December 23rd, 2013

Project Name: Munjoy Heights
Six new buildings comprising 29 residential townhouses; one existing house on reconfigured lot

Project ID: 2013-228

Project Address: 79 Walnut Street

SHEET TITLE:  
PILE & LAGGING RETAINING WALL SEQUENCING SECTIONS

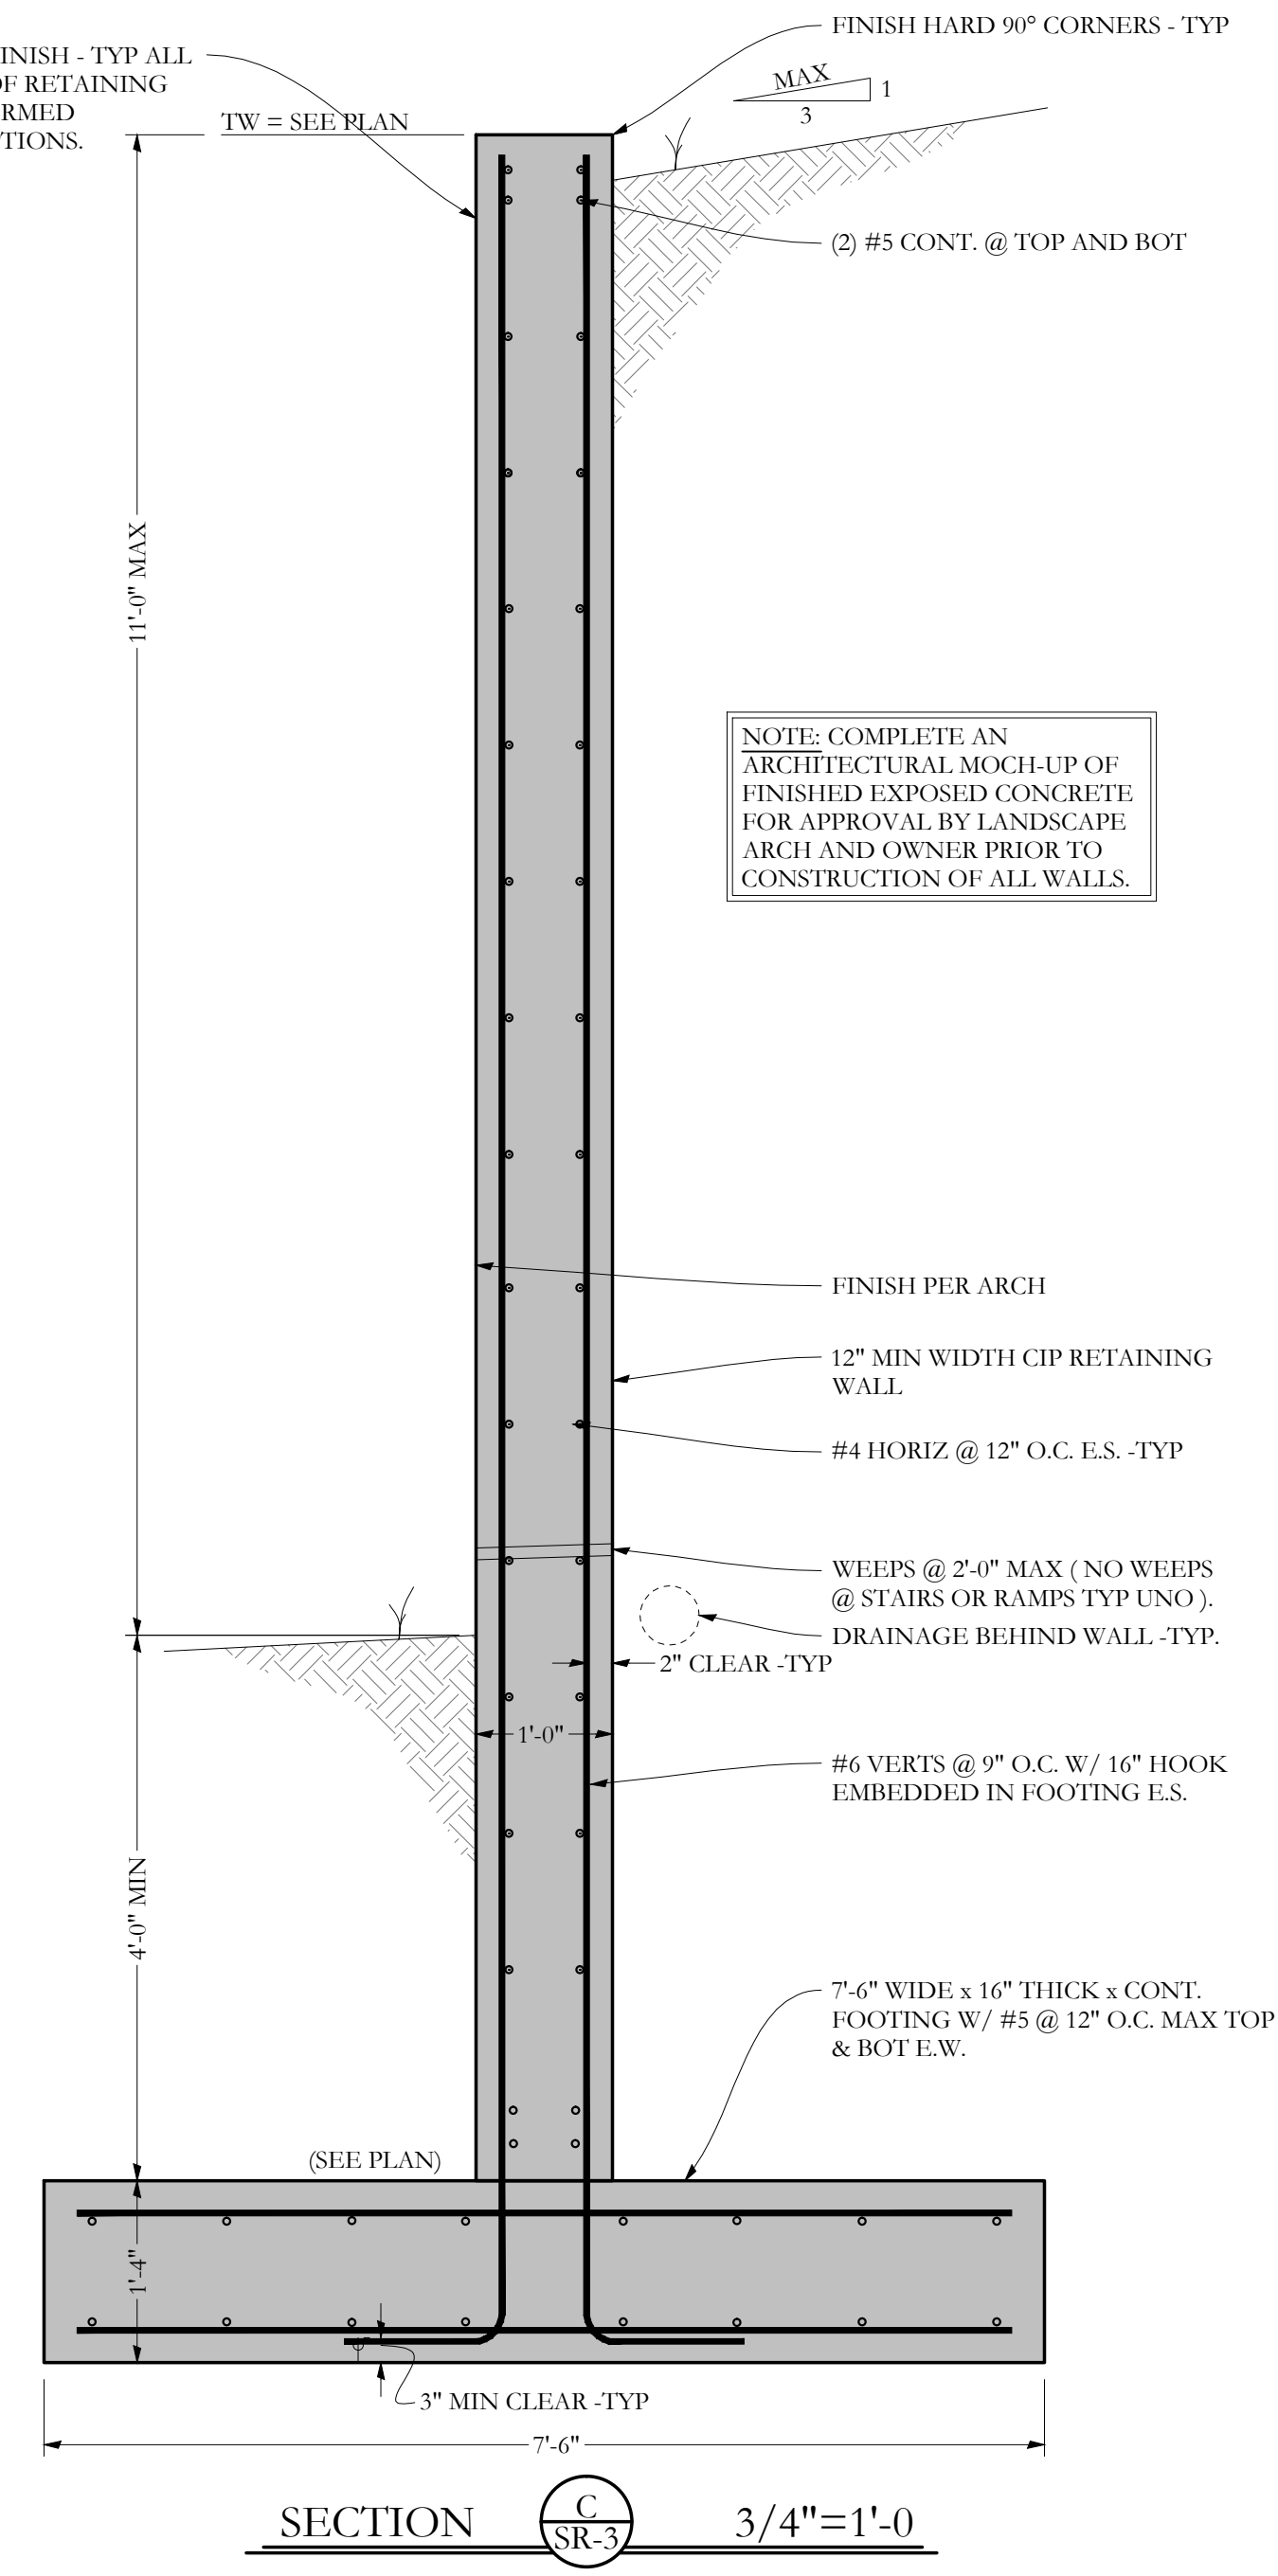
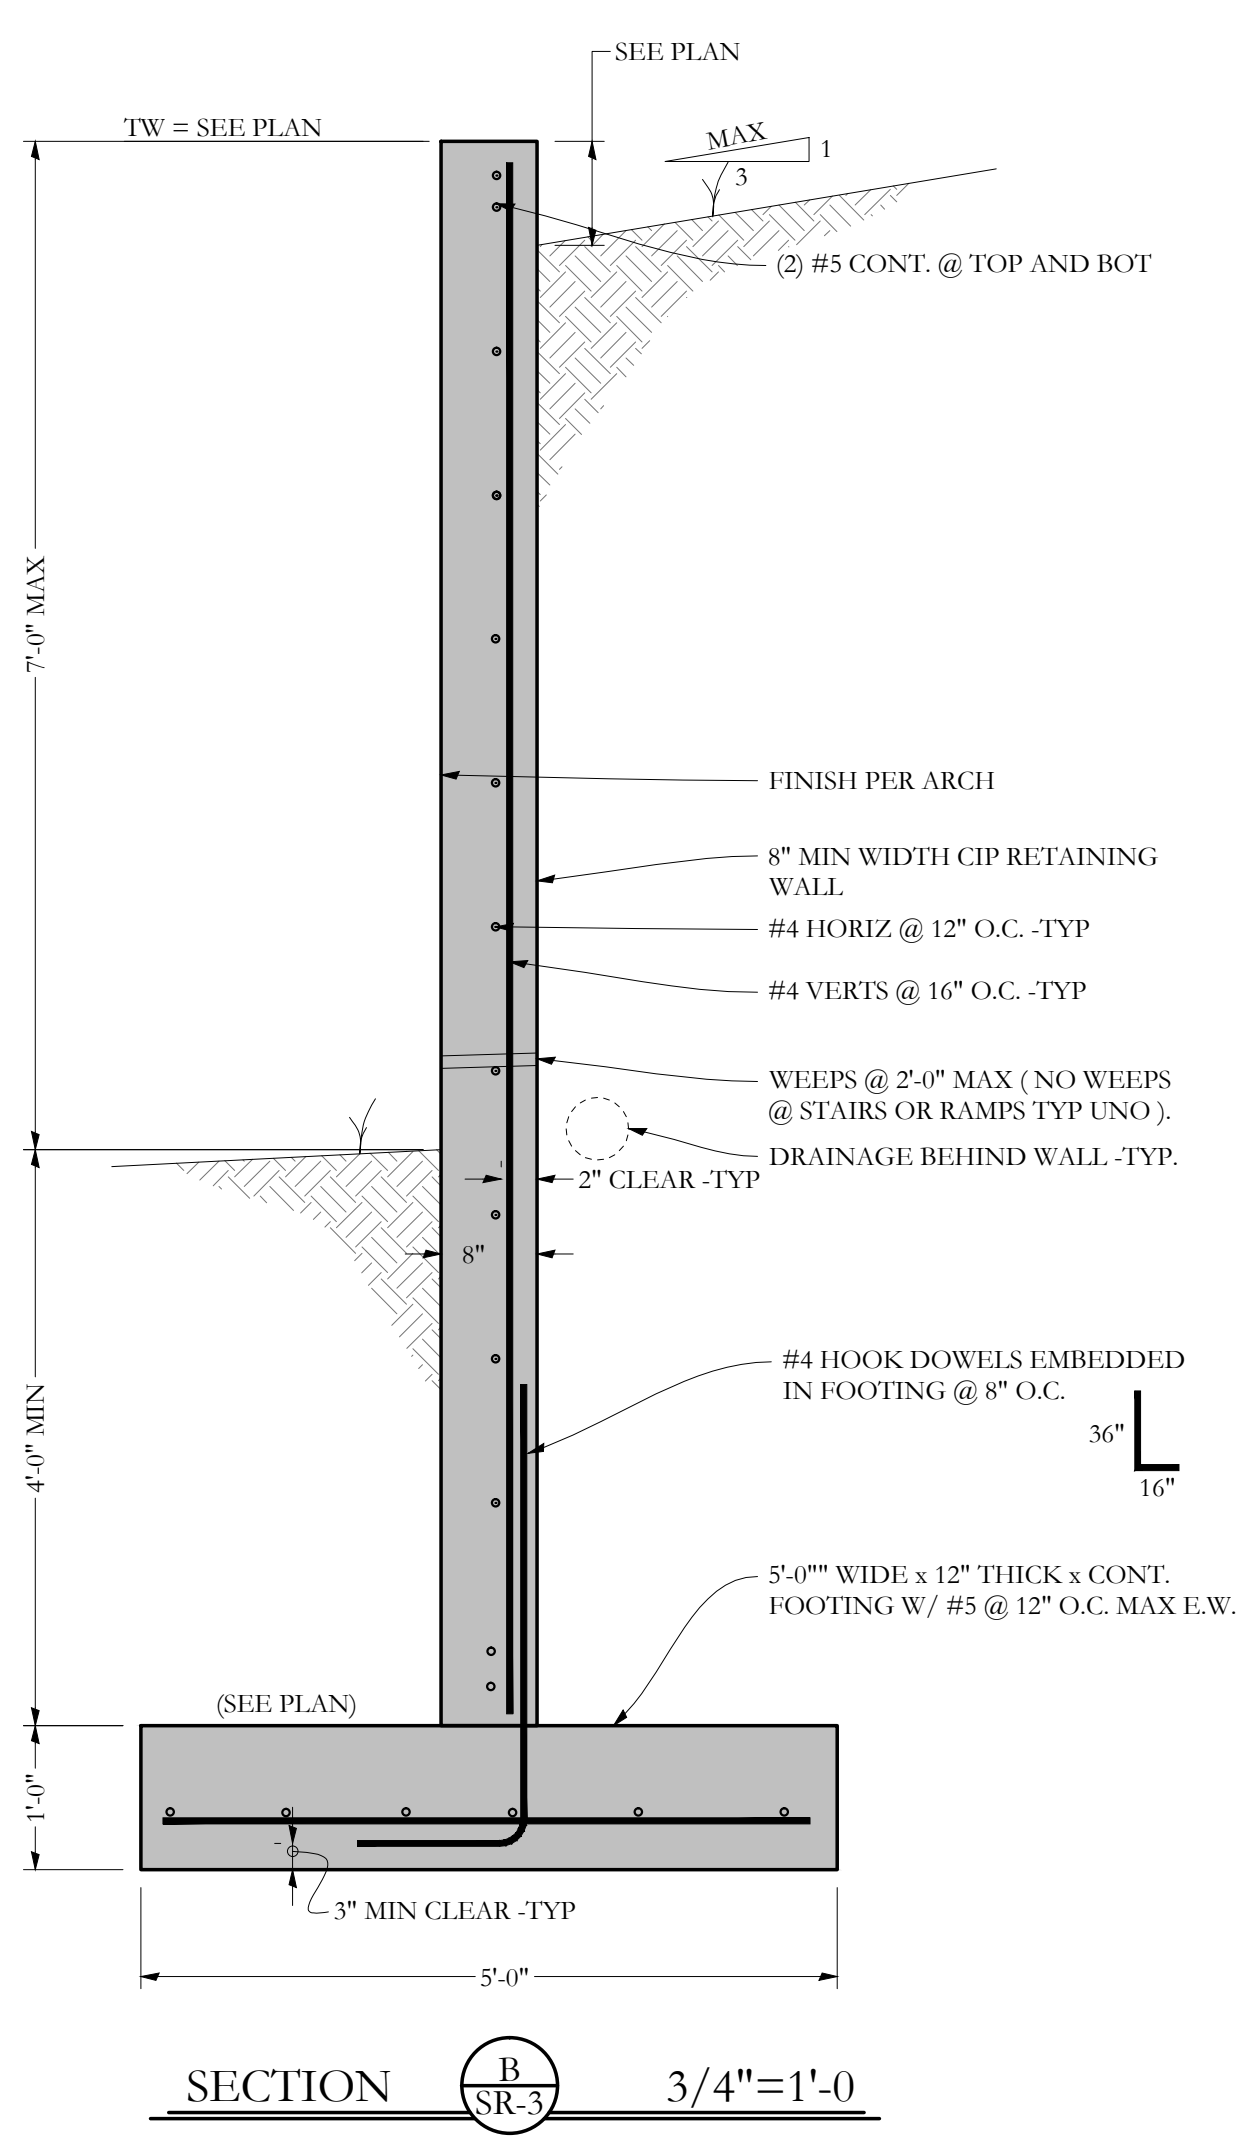
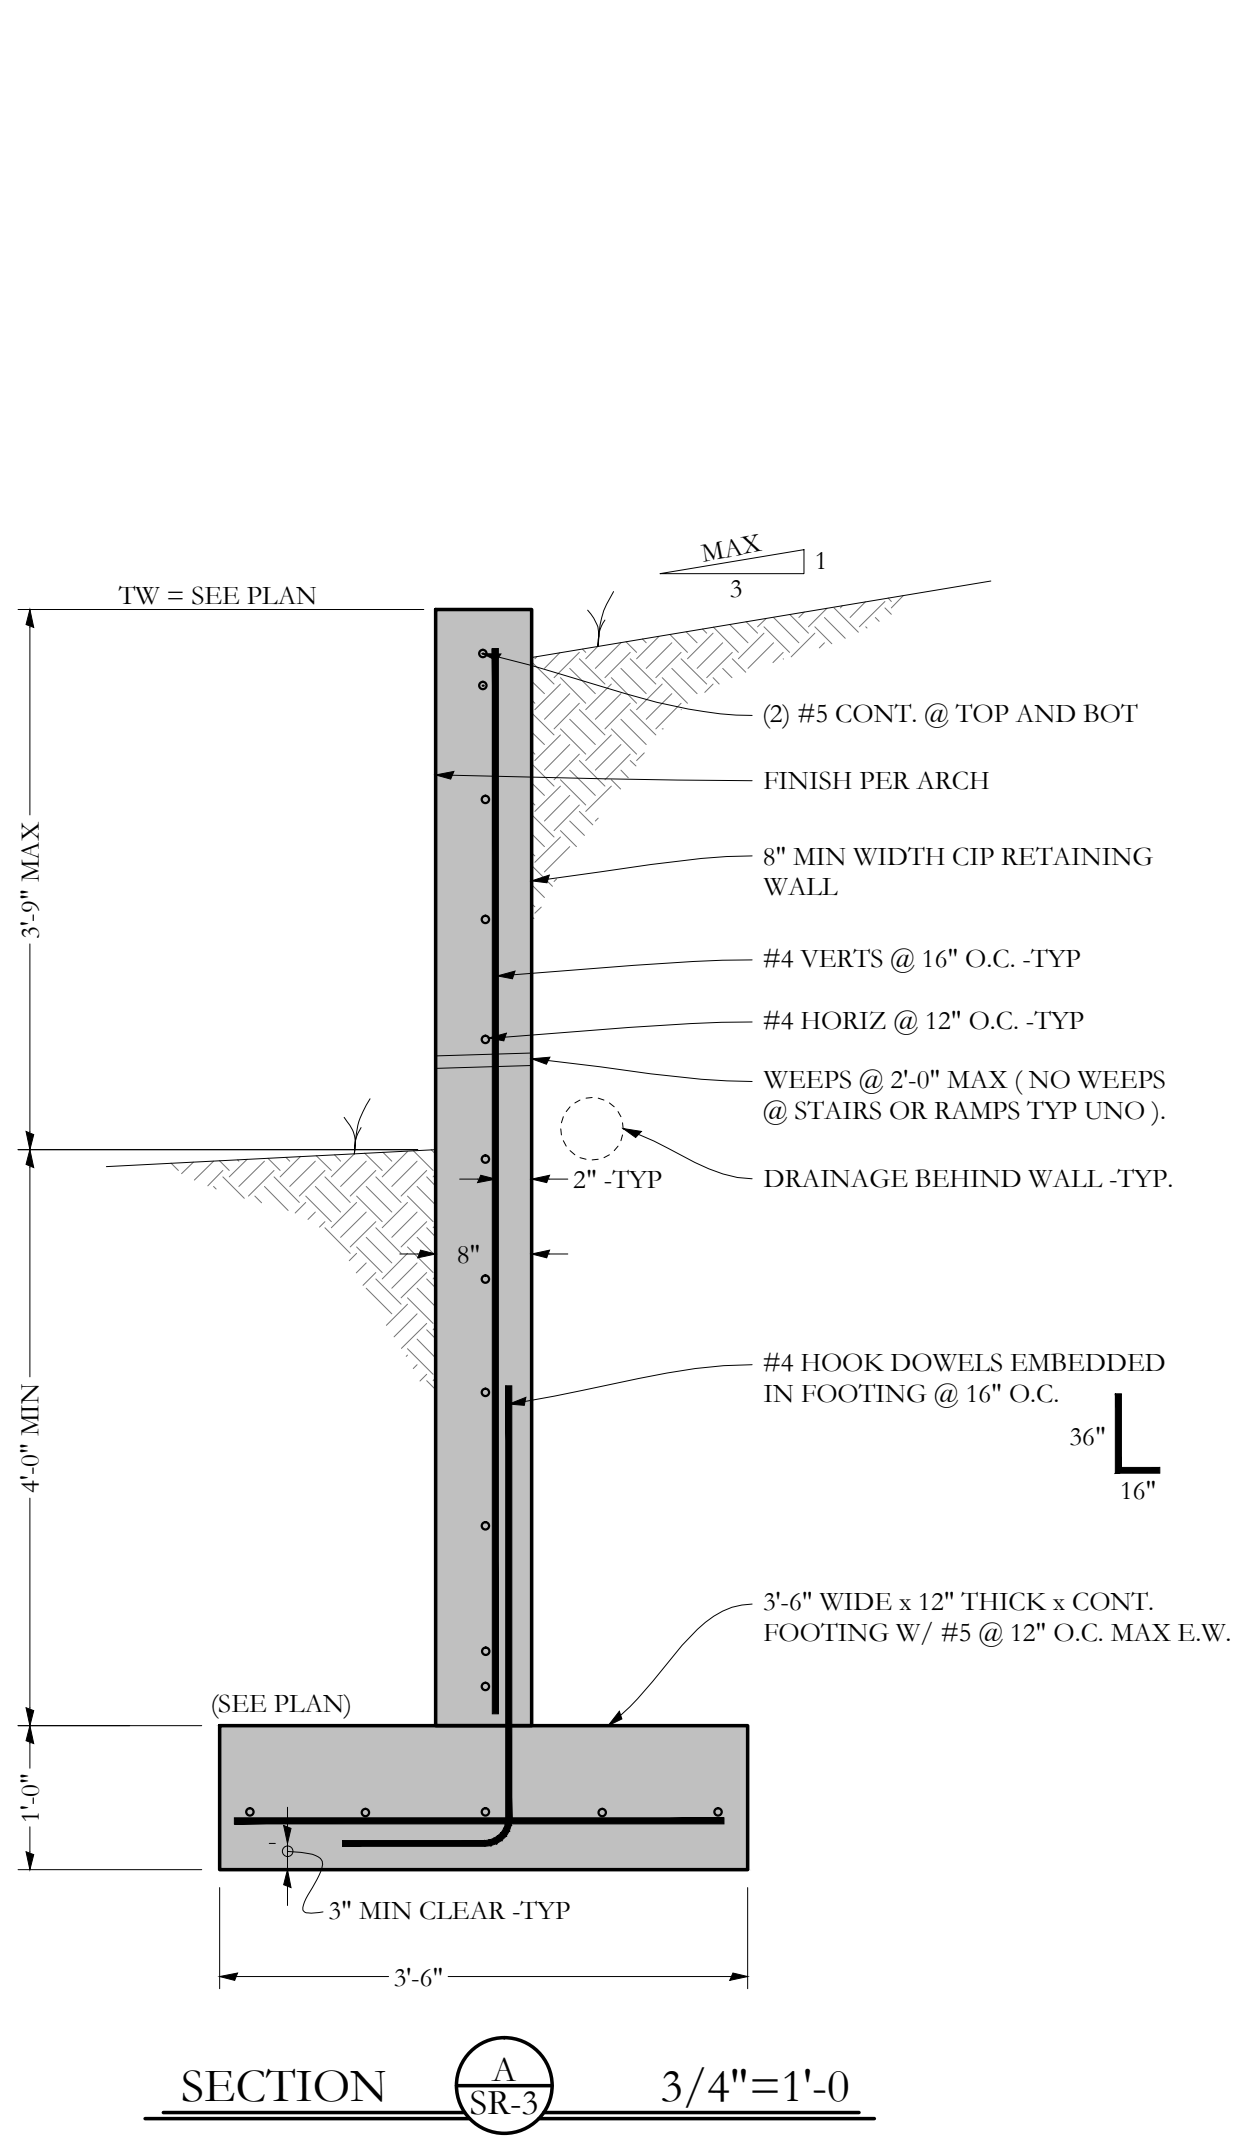
- vi. The applicant has noted on Plans Sheet C-32 & C-33 that Summit Engineering Services in coordination with Structural Integrity Consulting Engineers, Inc shall provide the retaining wall design, global stability analysis, and the design of the temporary soil restraint measures, as required. The referenced retaining wall designs shall be completed, stamped by a professional engineer, and submitted to the City of Portland Inspections Department and Planning Authority as part of the Building Permit process prior to construction of any retaining walls; and
